37 Sea Lane Gardens, Ferring

Ref: Proposed development of 26 Little Paddocks, Ferring. FG/47/13

SOUTH ELEVATION
(As Proposed)

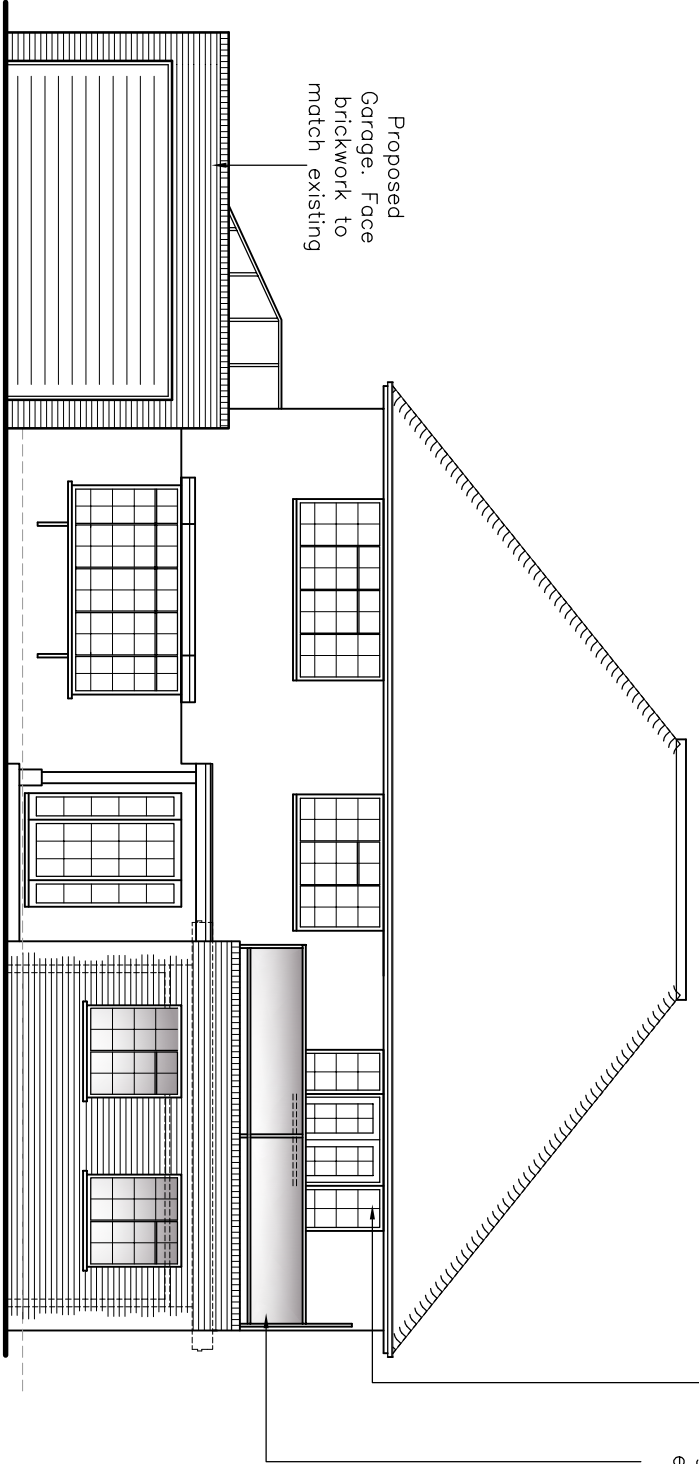
Firstly, the proposed extension to the south of the bungalow will affect our light, especially in the latter half of the day. I have enclosed a copy of a Google aerial map showing the proximity of the south face of the property to our shared fence, a distance of 3.93m [re Google Earth measurement].
